Application no: 21/03177/F

Location: Axis J9 Phase 3 Howes Lane Bicester

Lead Local Flood Authority

Objection

PHASE 3 External Works & Levels

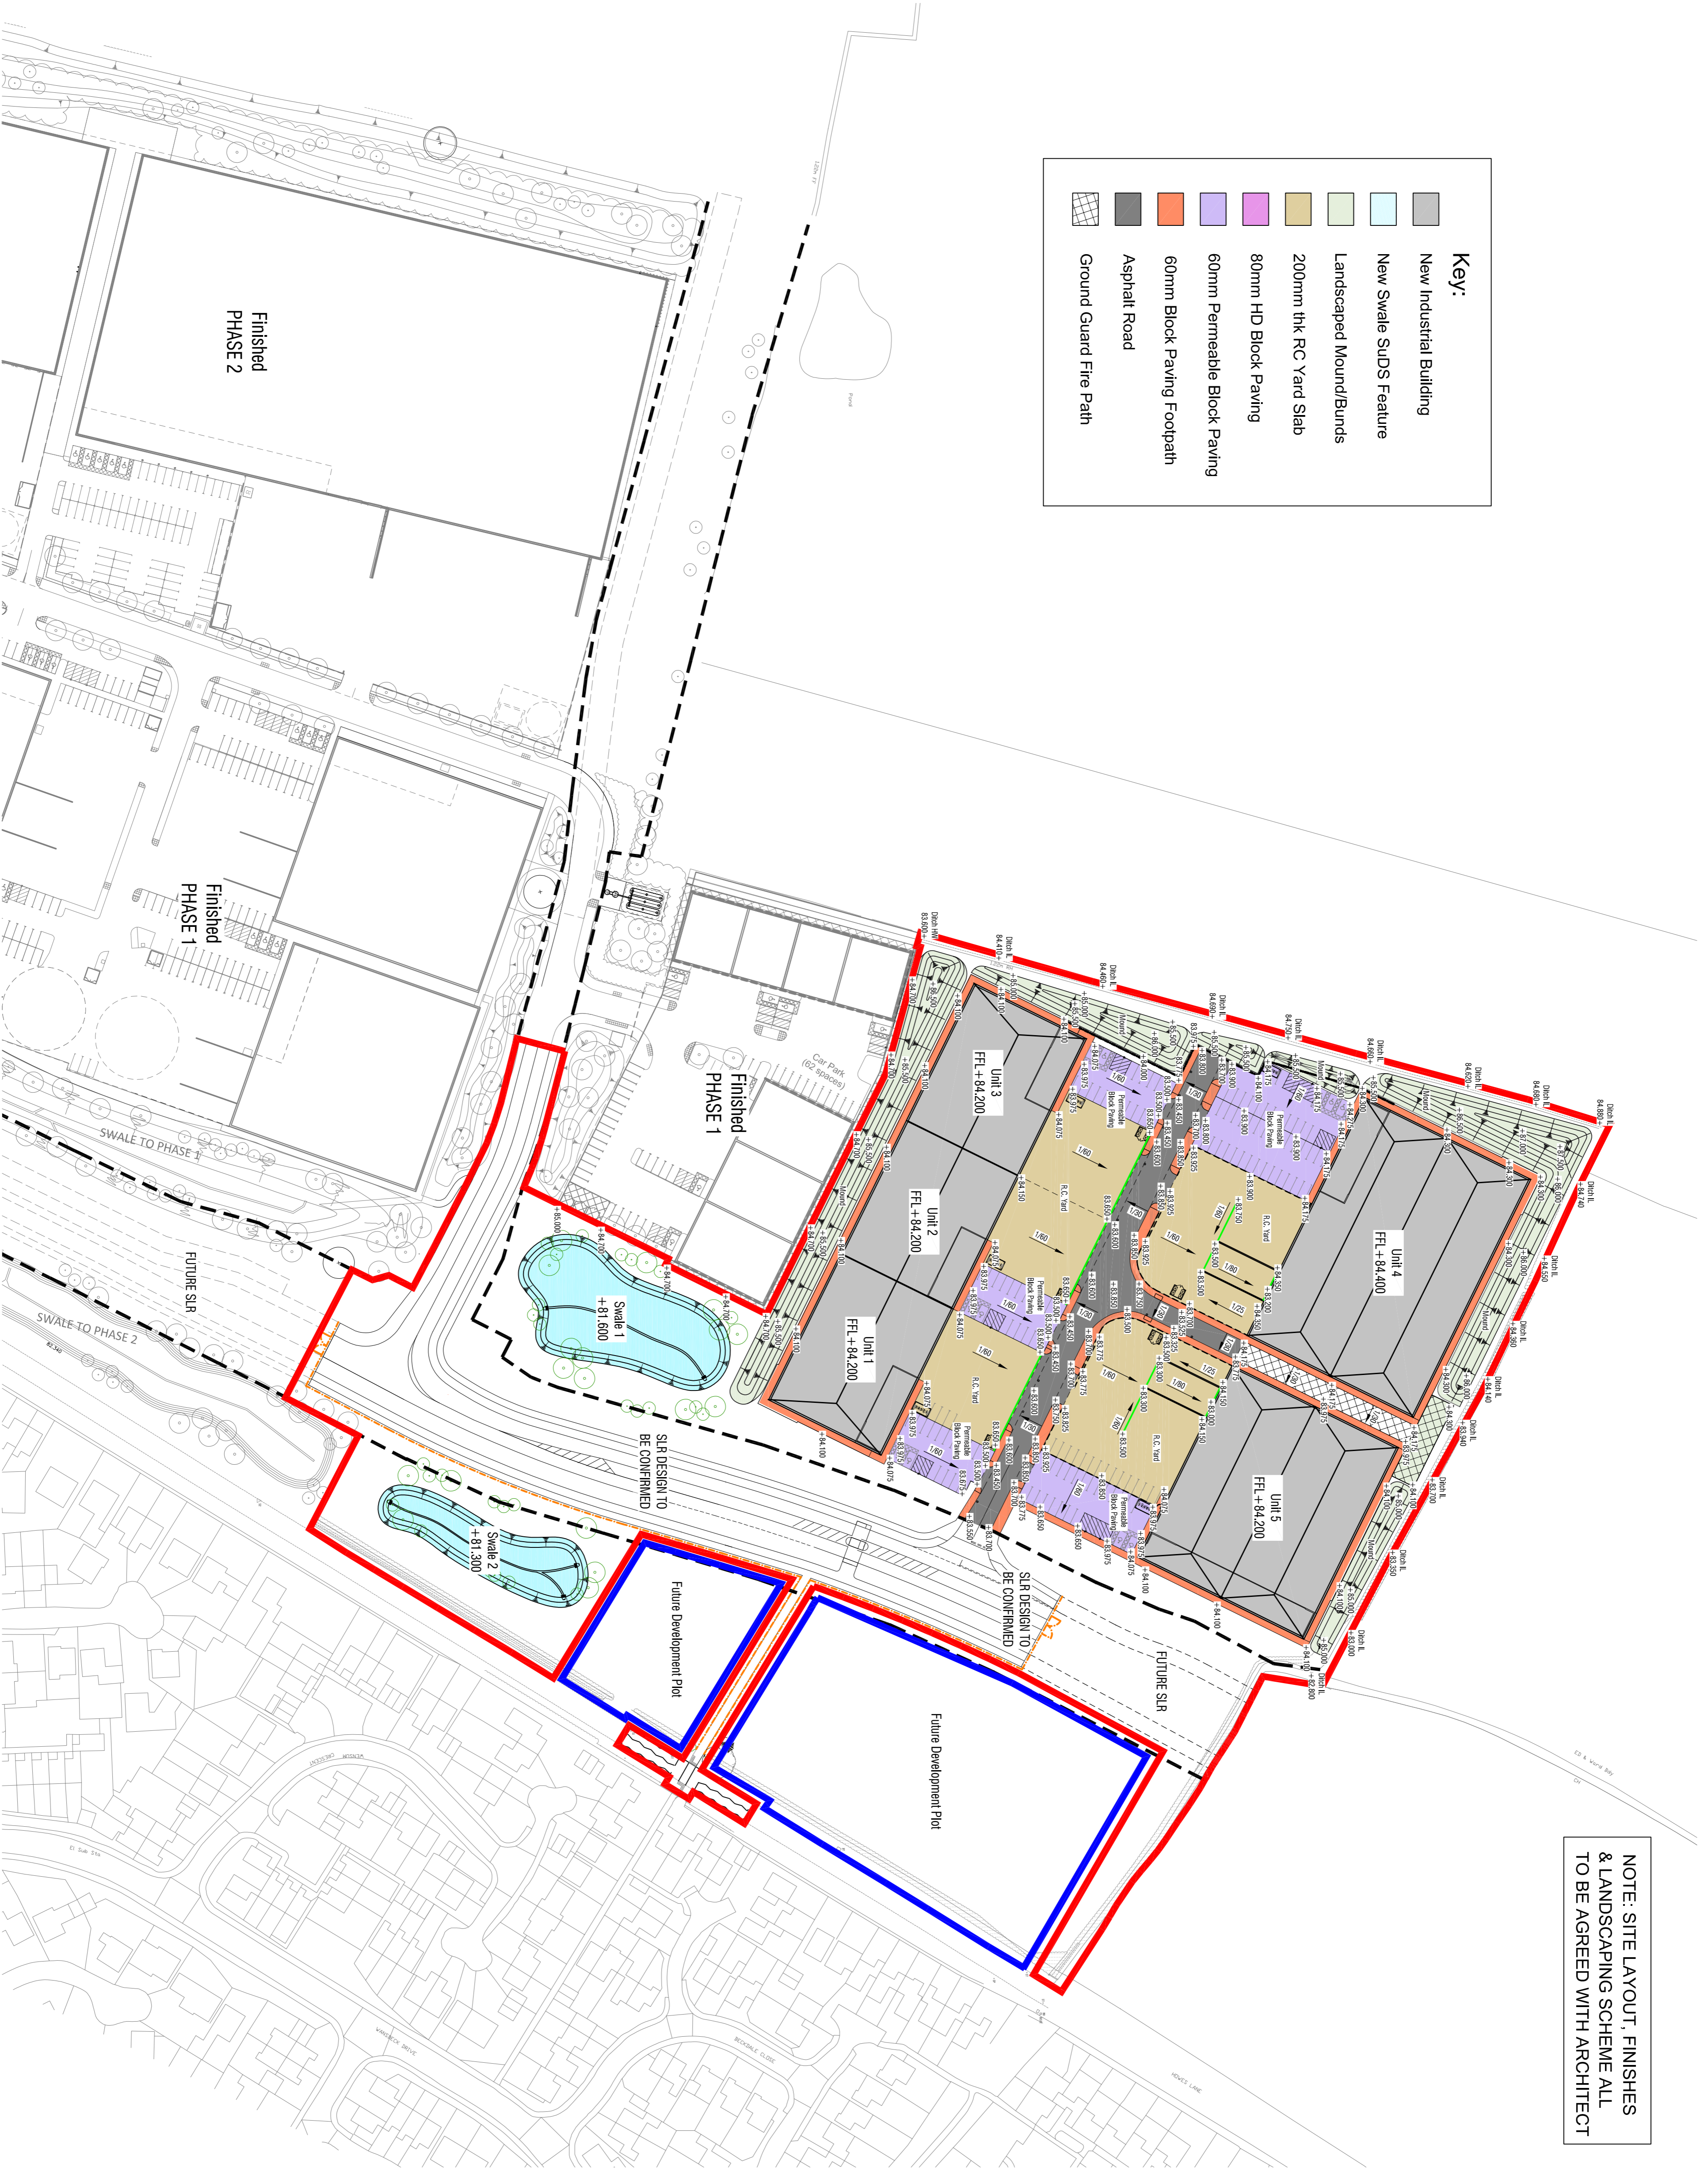
There are proposals within the application boundary that has not been included in the drainage strategy. From the architects layout there are many hard standing areas that has no drainage strategy, for instance the road that is going around phase 1 and 2.

Plan drawing shows headwall discharging to an green hatched area. This has not been denoted on the key.
